From: Simon Davis
Sent: 20 April 2021 16:47
To: 'Luke Challenger' [REDACTED]
Subject: RE: Y/19/21/PL & Y/18/21/RES - Clays Farm North End Road Yapton BN18 0DT

Subject: Y/19/21/PL & Y/18/21/RES - Clays Farm North End Road Yapton BN18 0DT

Regarding Y/18/21/RES, I have now assessed the application and provide the following comments:

Project	Clays Farm, Yapton				
Drawing	House Type A22 (3 Block) Floor Plans				
Client	Aster Group				
Job no.	ASTE200629			Date	Jan'2021
Dwg no.	HT.A22(3Blk).p			Rev.	A
Author	MS	Checker	AS	Scale	1:100 at A3
Status	PLANNING			Office	Romsey
Client ref.

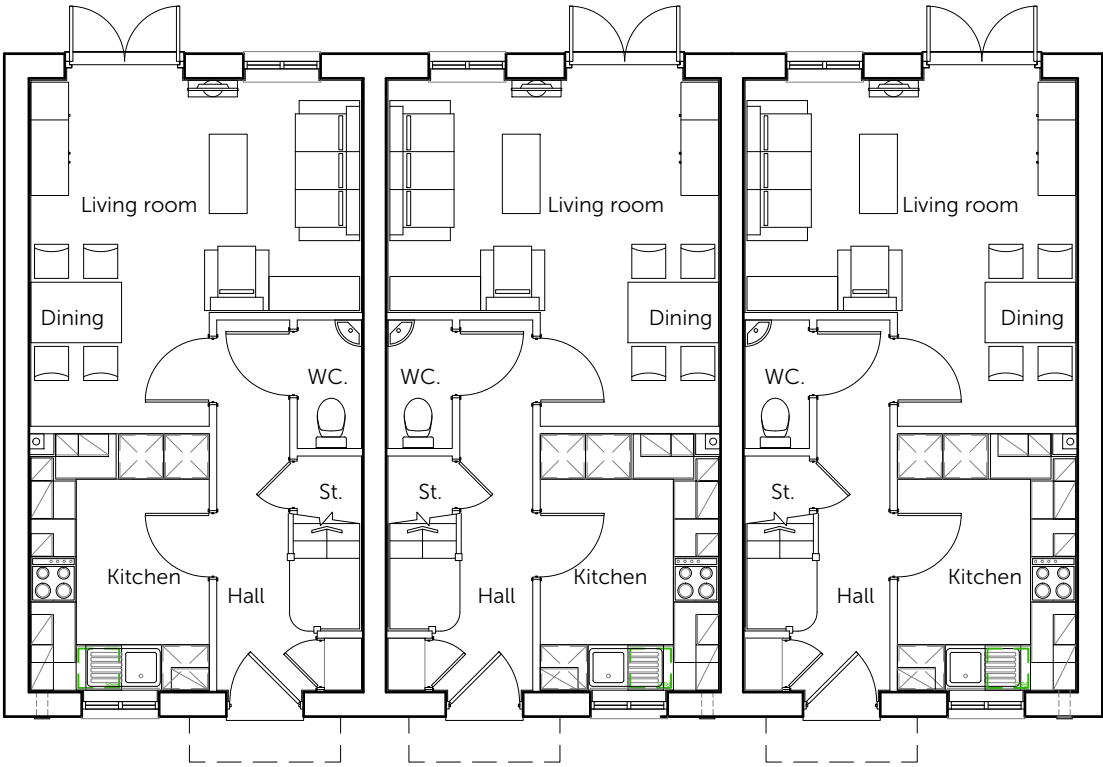
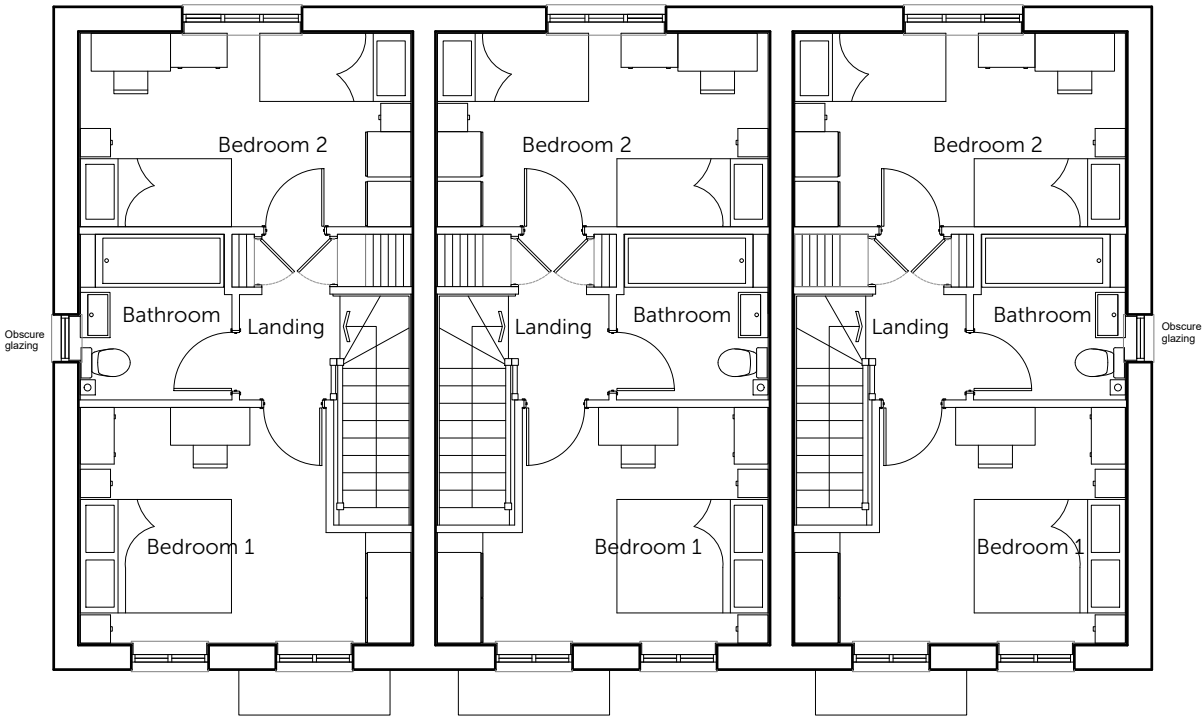
- It appears that the garages are undersized versus the standard in the Arun Design Guide. To be counted as half a space each, garages must be at least 6m by 3m. The garages in the scheme are 5.88m by 3.09m. However, even if the garages are not included, the parking provision still exceeds the requirement so there is no need to enlarge these.

- I have a concern with the 2 visitor spaces in front of plots 31-33. I believe that in this position they will just be used by the occupiers of those homes. I suggest relocating these to the opposite side of the road and further west into the site.
